VOLLMER RV STORAGE

EPC STORMWATER REVIEW COMMENTS
IN GRANGE BOXES WITH BLACK TEXT

GRADING AND EROSION CONTROL PLAN

VOLLMER RV STORAGE
EROSION CONTROL PLAN

VOLLMER RV STORAGE
EROSION CONTROL PLAN

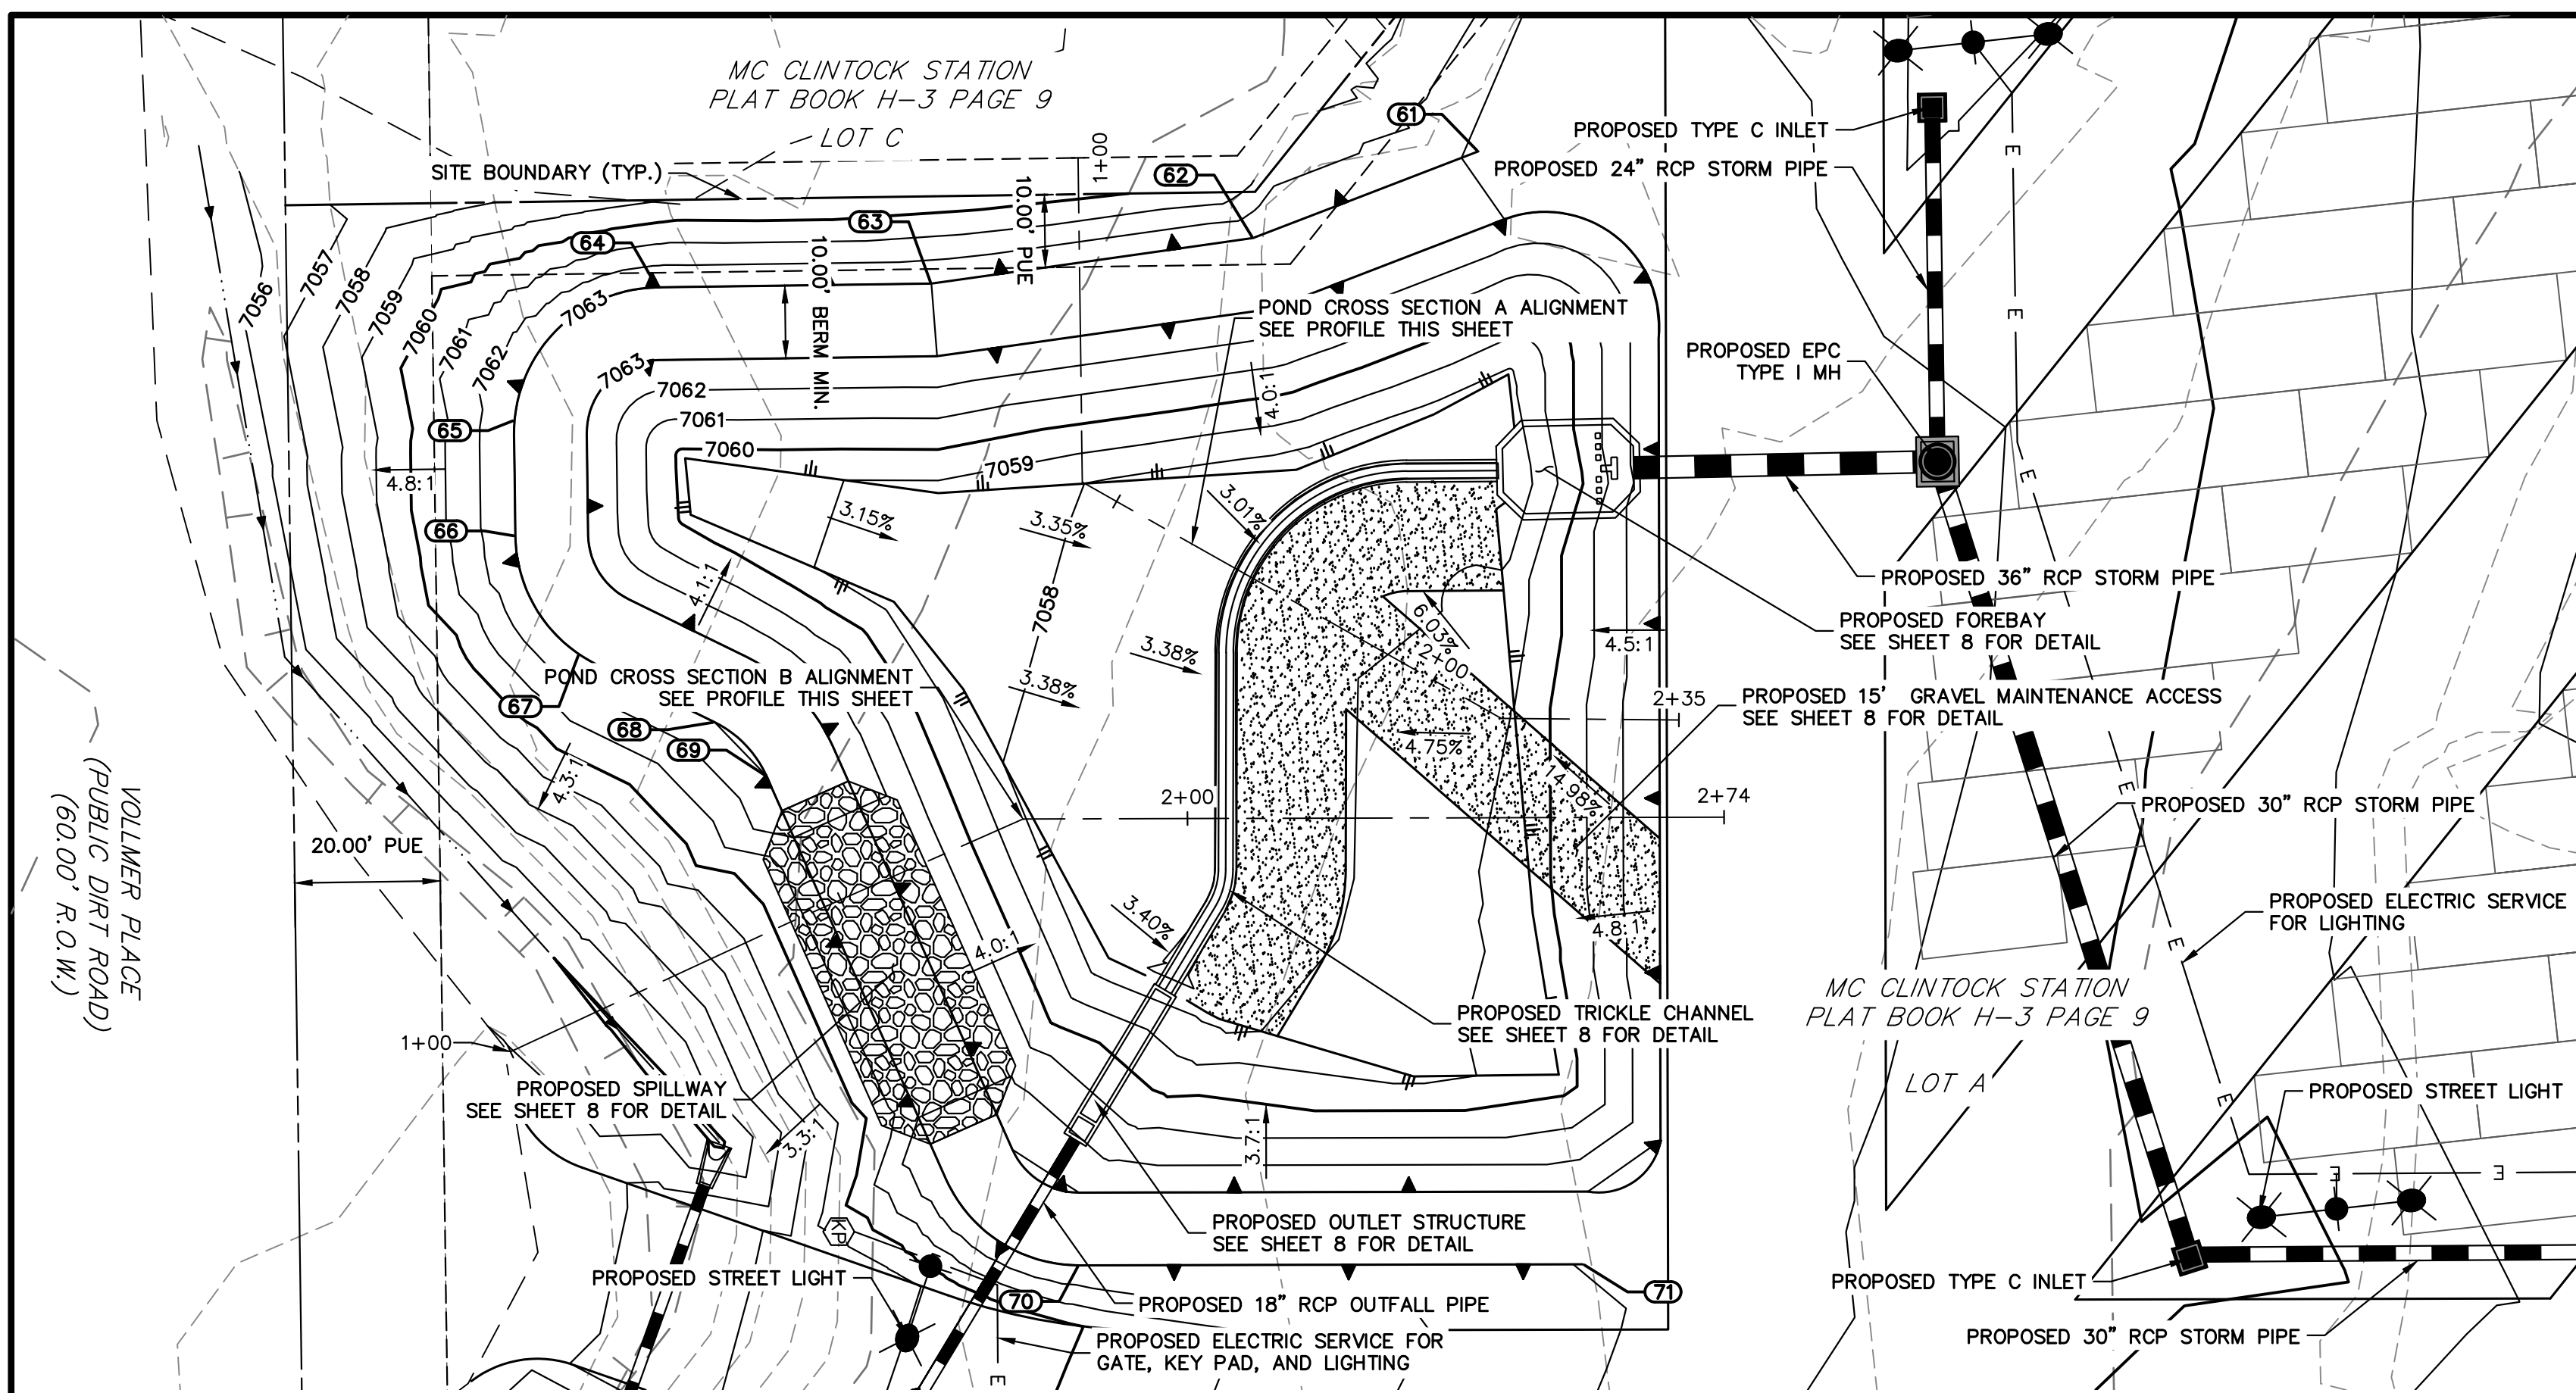
It is the opinion of the engineer that Vollmer Place meets the intentions of the rural gravel local roadway cross-section. While there are no well defined ditches present along the road, this is consistent with the Drainage reports in the area. There are no noted negative impacts to the roadway in its current condition. Therefore it is believed to be in well working and operating condition, acceptable for the existing and proposed business access as shown in the Traffic Impact Study performed for this site.

Roadway will need to meet ECM Standard SD 2-10 for Rural Gravel Local Roadway.

Work in ROW permit will be required to any work done within County ROW.

Addressed: See updated note 3
